ECOVE GROUP

SITE 68 – SYDNEY OLYMPIC PARK

ACCESS REVIEW

19 September 2014

**1 BEDROOM APARTMENT:  
PRE ADAPTION**

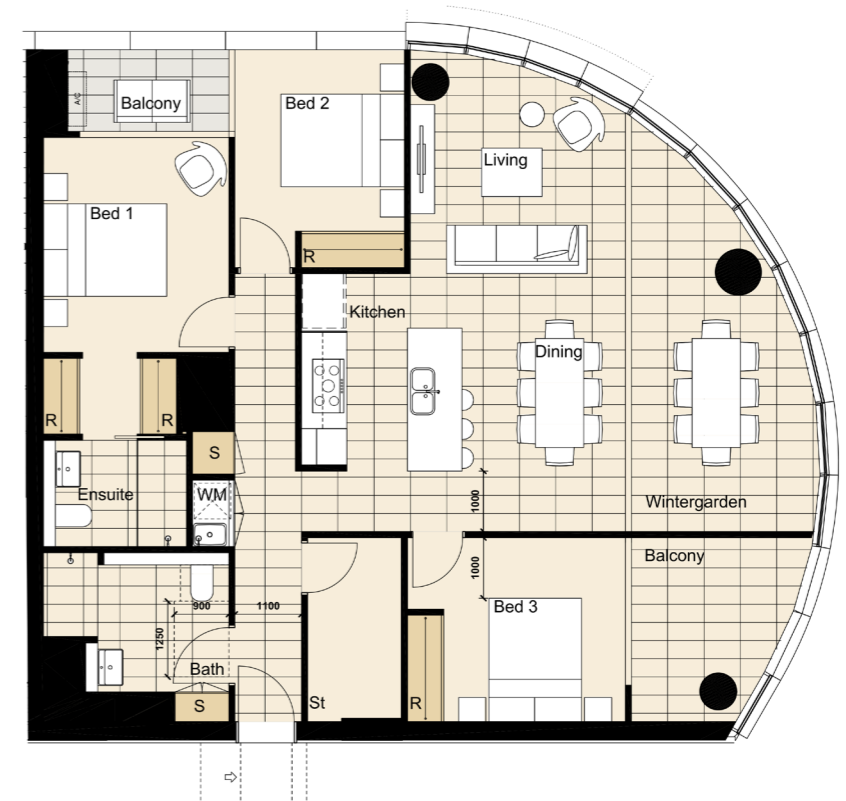
5.2. Adaptable Unit Design – 1 Bedroom (DA16.01[02])

The bathroom has suitable pre-adaption provisions to achieve the required circulation spaces at post-adaption stage. The toilet pan is located adjacent to a fixed wall at pre-adaptation, to ensure grab rails can easily be installed in the future.

The provision of extra plumbing provisions (capped off wastes and supply pipes) in place at pre-adaption stage will allow the basin and laundry facility

to be re-located at post adaption. There is suitable 1550mm diameter unobstructed circulation area in front of the laundry area at post-adaptation.

- (i) All joinery/walls proposed to be removed at post-adaption to have continuous flooring under and be free of all services from the outset, compliant with AS4299 and AS1428.1-2009.
- (ii) Pre-adaption drawings for bathroom to include extra capped off plumbing services for basin and laundry to allow for re- location in compliance with AS1428.1 at post adaption stage. In addition continuous water-proofing/tiling is to be provided behind joinery for ease of removal and adaption.
- (iii) Provide slip-resistant floor surface with minimum wet pendulum test rating of 'X' (under HB197/AS4856) in kitchen, laundry and adaptable bathroom at pre-adaption as required by AS4299 clause 4.5.4.

**3 BEDROOM APARTMENT:  
PRE ADAPTION**

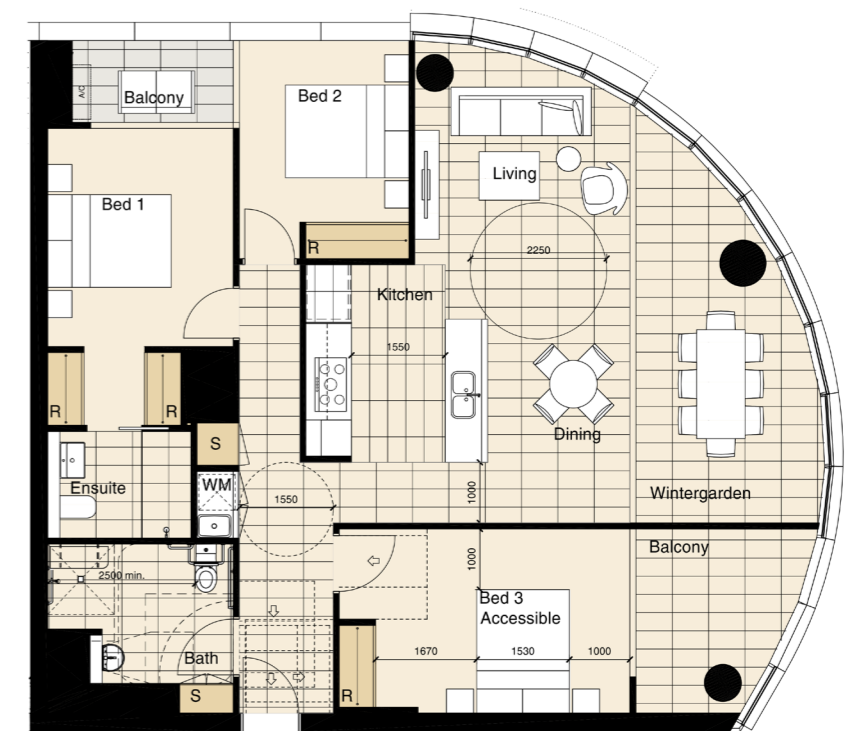
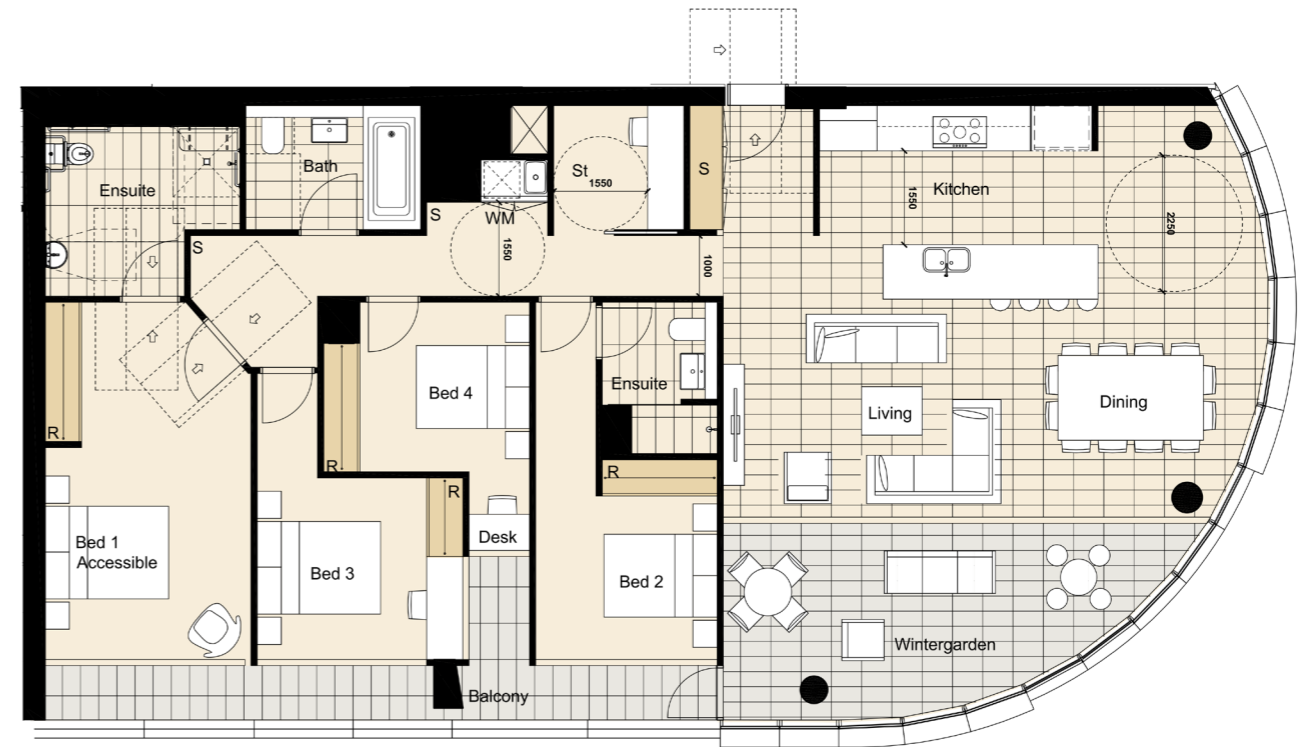
5.3. Adaptable Unit Design – 3 Bedroom Type 3A (DA16.02[07])

The entry door of adaptable units has suitable external door circulation compliant with AS4299 and AS1428.1-2009. The design facilitates suitable provisions to allow easy modification to achieve required internal door latch side clearances at post-adaptation. This is achieved by modifying the wall of study room.

There are suitable 1550mm unobstructed circulation areas in front of the laundry area in modifying the location the wall of the study room. The kitchen island allows for easy adaptation, to achieve minimum 1550mm diameter unobstructed circulation area between kitchen benches.

- (i) All joinery/walls proposed to be removed at post-adaption to have continuous flooring under and be free of all services from the outset, compliant with AS4299 and AS1428.1-2009.

- (ii) Provide continuous water-proofing/tiling behind joinery for ease of removal and adaption.
- (iii) Provide slip-resistant floor surface with minimum wet pendulum test rating of 'X' (under HB197/AS4856) in kitchen, laundry and adaptable bathroom at pre-adaption as required by AS4299 clause 4.5.4.

**4 BEDROOM APARTMENT:  
PRE ADAPTION**

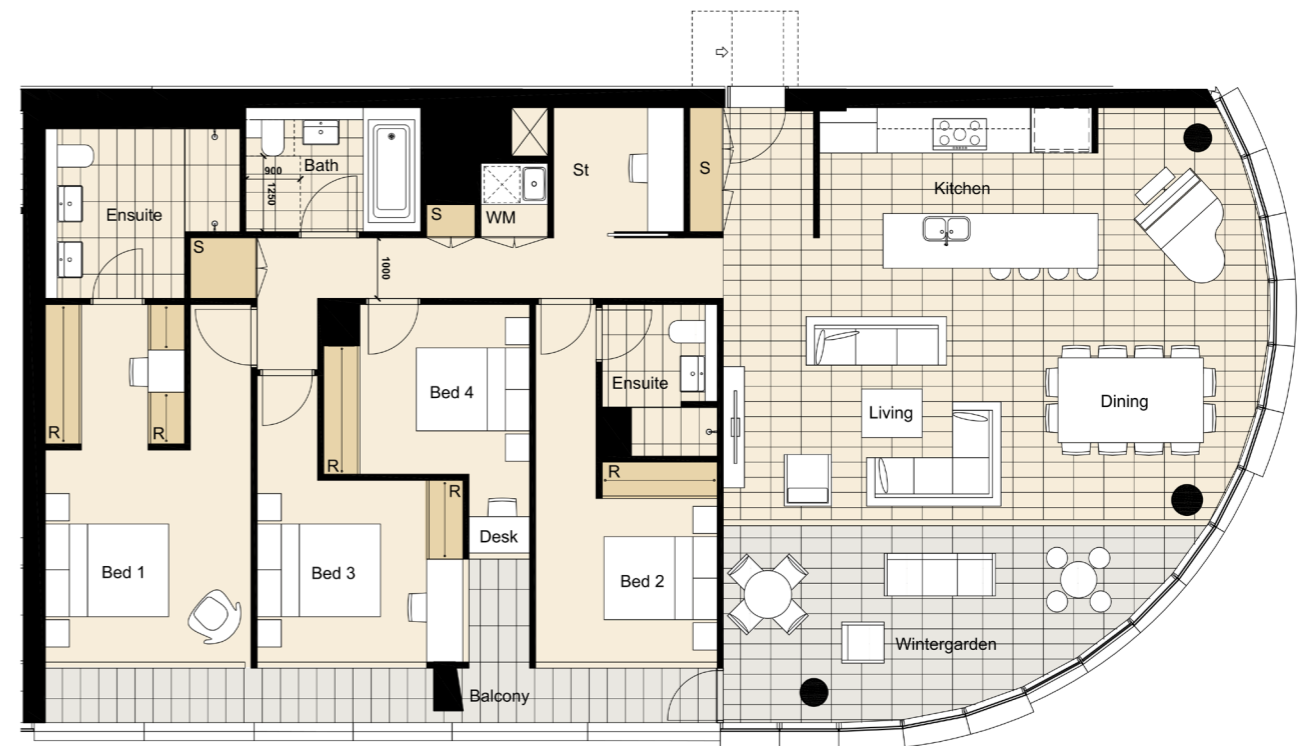
5.4. Adaptable Unit Design – 4 Bedroom Type 4A (DA16.03[02])

The adaptable bedroom has adequate clearances to allow easy modification at post adaptation with removal of storage unit and desk, to achieve suitable circulation areas in front of the wardrobe and around the bed.

The bathroom has suitable pre-adaption dimensions to achieve the required circulation spaces at post-adaption stage. Only the door to bathroom will need to be modified to achieve required circulation areas. The toilet pan is located adjacent to a fixed wall at pre-adaptation, to ensure grab rails can easily be installed in the future.
